A1 Birtley to Coal House
Scheme Number: TR010031

Applicant's Response to ExA's Third Written
Questions

Rule Number:	Rule 8(1)(b)
Planning Inspectorate Scheme Reference	TR010031
Application Document Reference	Applicant's Response to ExA's Third Written Questions
Author:	A1 Birtley to Coal House Project Team, Highways England

Version	Date	Status of Version
Rev 0	9 June 2020	For Issue

Section	Type	ID	Direction	Type	Role	Number
B2CH

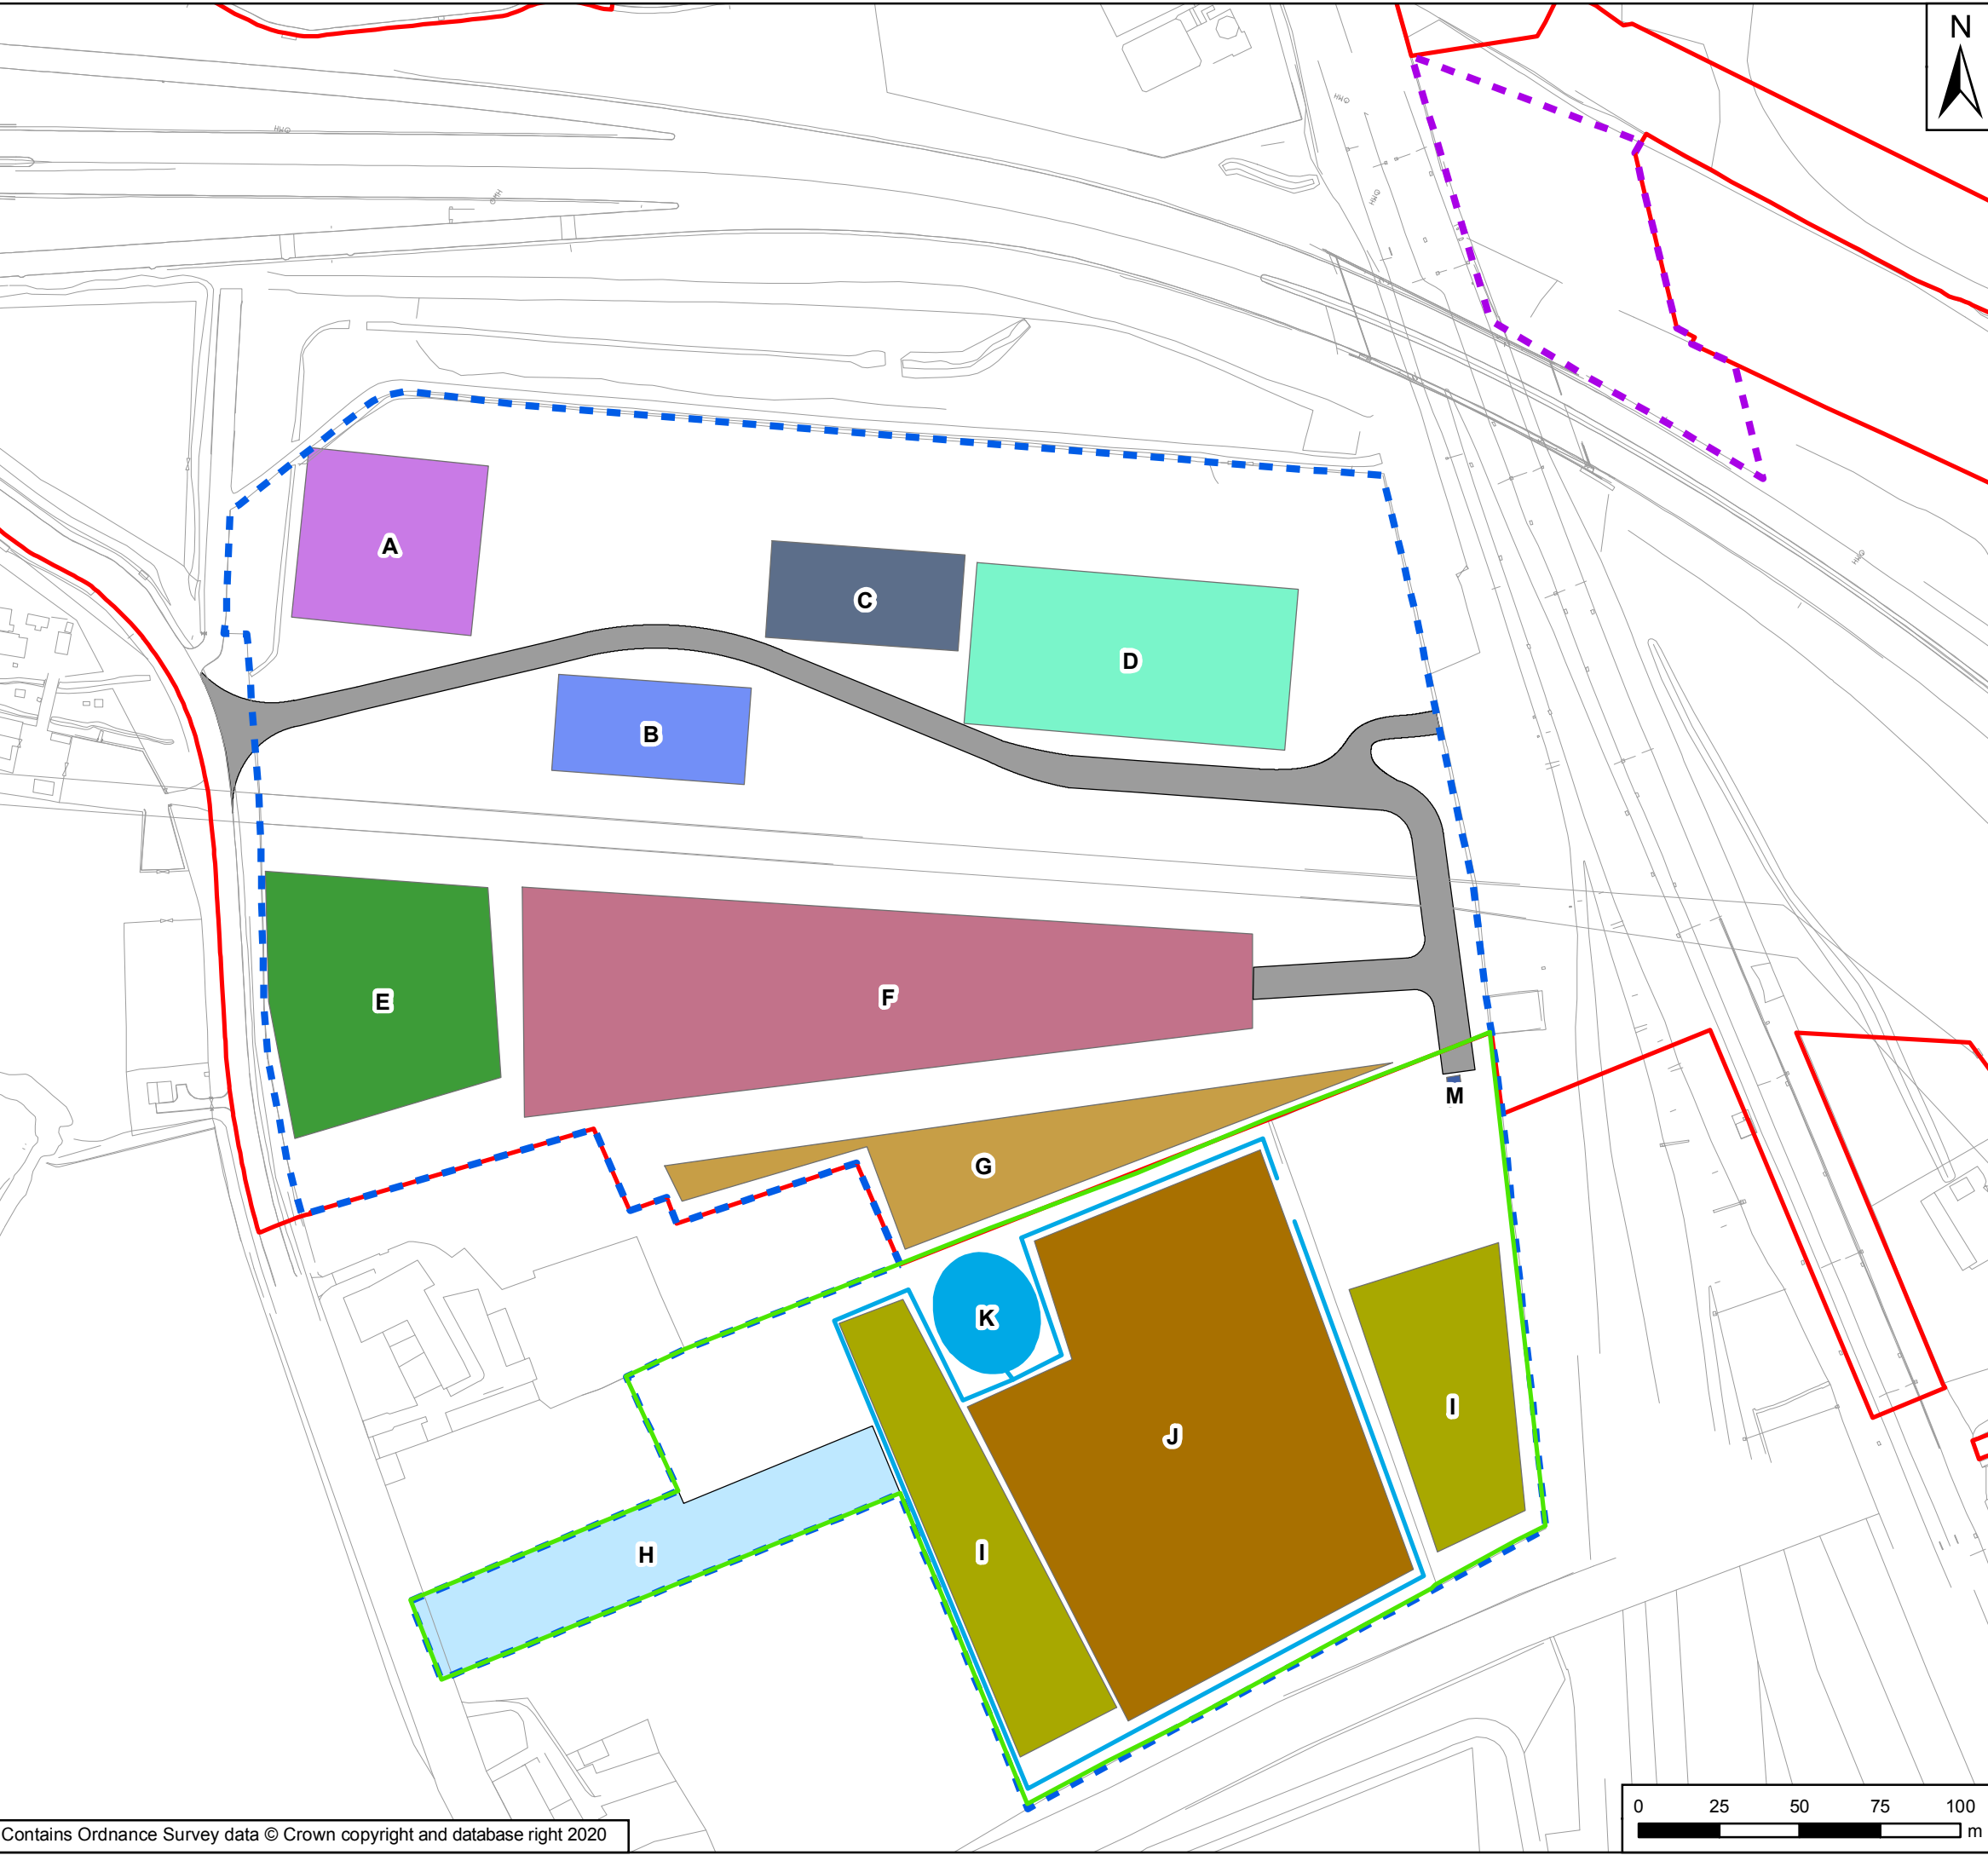
3.0.2	The Applicant	<p>Appendix A (site compounds) of the latest version of the outline CEMP [REP6-08] does not include the additional land to be used for material stockpiling.</p> <p>a) Can the Applicant include this additional land in the outline CEMP?</p>	<p>The new version of Appendix A - Figure 1 Site Compound Plan of the Outline CEMP [REP6-08 and 19] has been prepared that has been updated to include the additional land to be used for material stockpiling. This has been submitted as a new figure within Figure 1/AL, namely "Site Compound Plan Detailed View, Junction 67 (Additional Land)". This is contained within Figure 1/AL Site Compound Plan in Appendix A of the Outline CEMP [REP6-08 and 19], an updated version of which has been submitted as part of Deadline 8 (09 June 2020).</p> <p>In order to address the circumstances where the Secretary of State decides to grant compulsory powers over plot 3/13a, which is the additional land, the Outline CEMP [REP6-08 and 19], an updated version of which was submitted as part of Deadline 8 (09 June 2020), has been amended to provide that:</p> <p><i>"The final proposed layout of the construction compounds to be sited at Junction 67 and Eighton Lodge will be included in the CEMP and must be in substantial accordance with Appendix A - Figure 1/AL Site Compound Plan of the Outline CEMP. Where parcel 3/13a is included in the powers granted by the made DCO, the layout of the construction compound to be sited at Junction 67 shall be in substantial accordance with the image in Figure 1/AL Site Compound Plan Detailed View, Junction 67 (Additional Land)".</i></p>
